A57 LINK ROADS

TR010034

RESPONSES TO DEADLINE 2 SUBMISSIONS

CPRE PDSY DEADLINE 3 SUBMISSION – RESPONSE TO DEADLINE 2 SUBMISSIONS

Figure 7-2 Journey Time Analysis, additional routes assessed (Do Minimum (DM) and Do Something (DS))

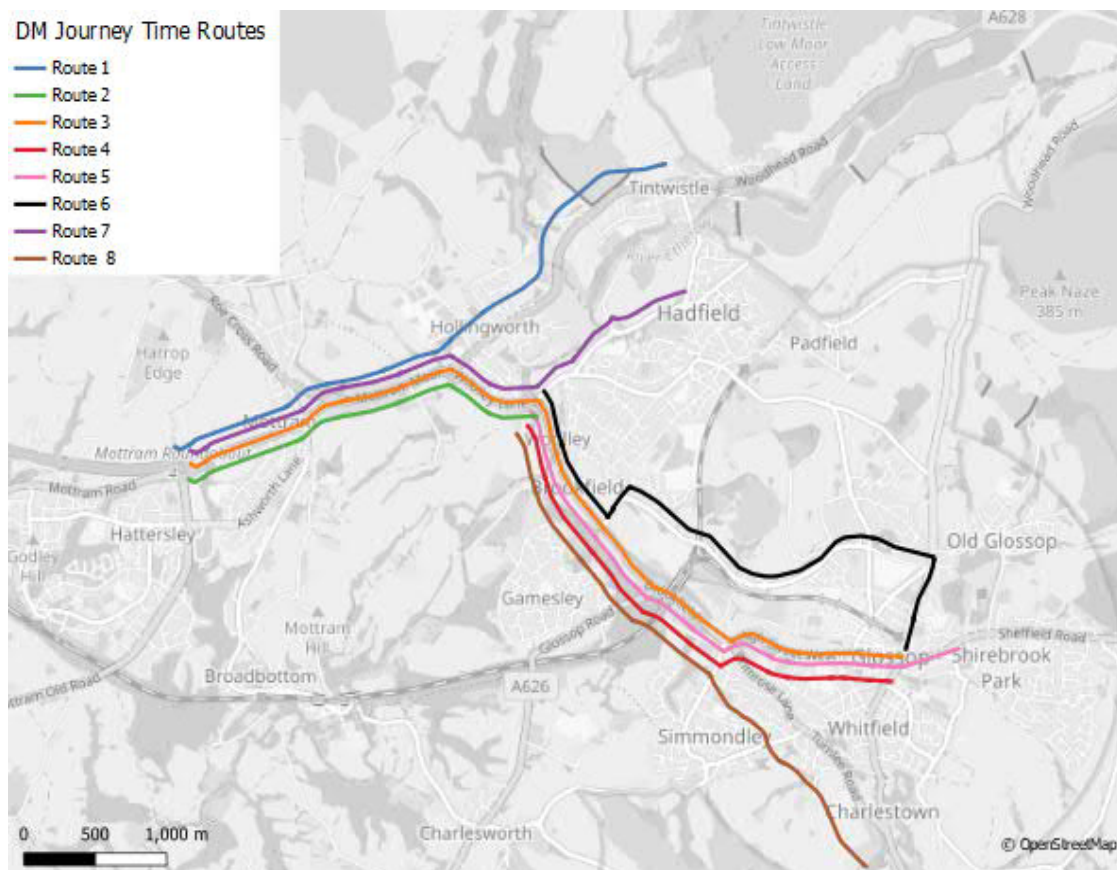
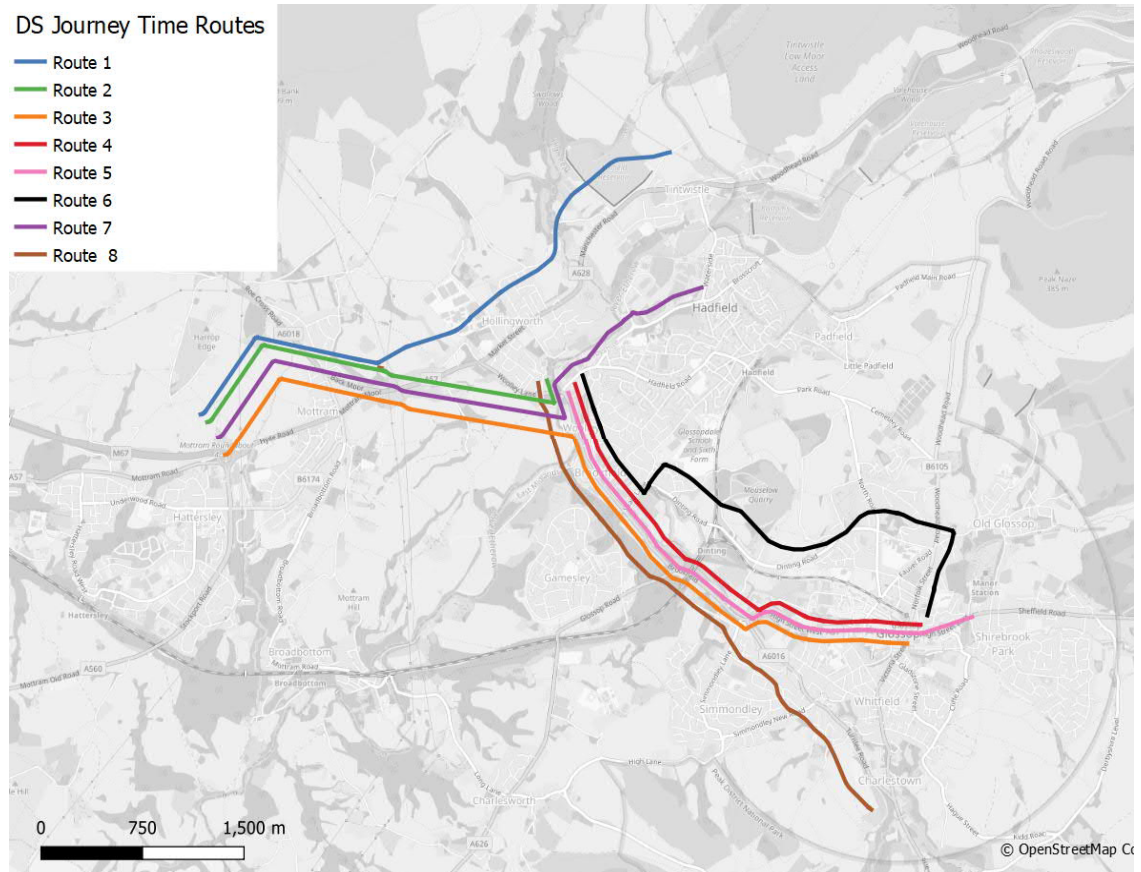
1. NH has not satisfactorily answered this question. The DCO boundary excludes the whole of Glossop and Hadfield/Padfield. DCC presents compelling evidence that journey times within Glossop would increase with the scheme in place due to congestion (Local Impact Report paras 7.30-7-31; Figure 7-2 & 7-3; Table 7-1¹). The scheme also causes traffic to use alternative routes and appears to create another major route – the Hadfield Alternative along Dinting Road². In his written representation, Peter Simon has demonstrated the substantial impacts this would have on this residential road³.
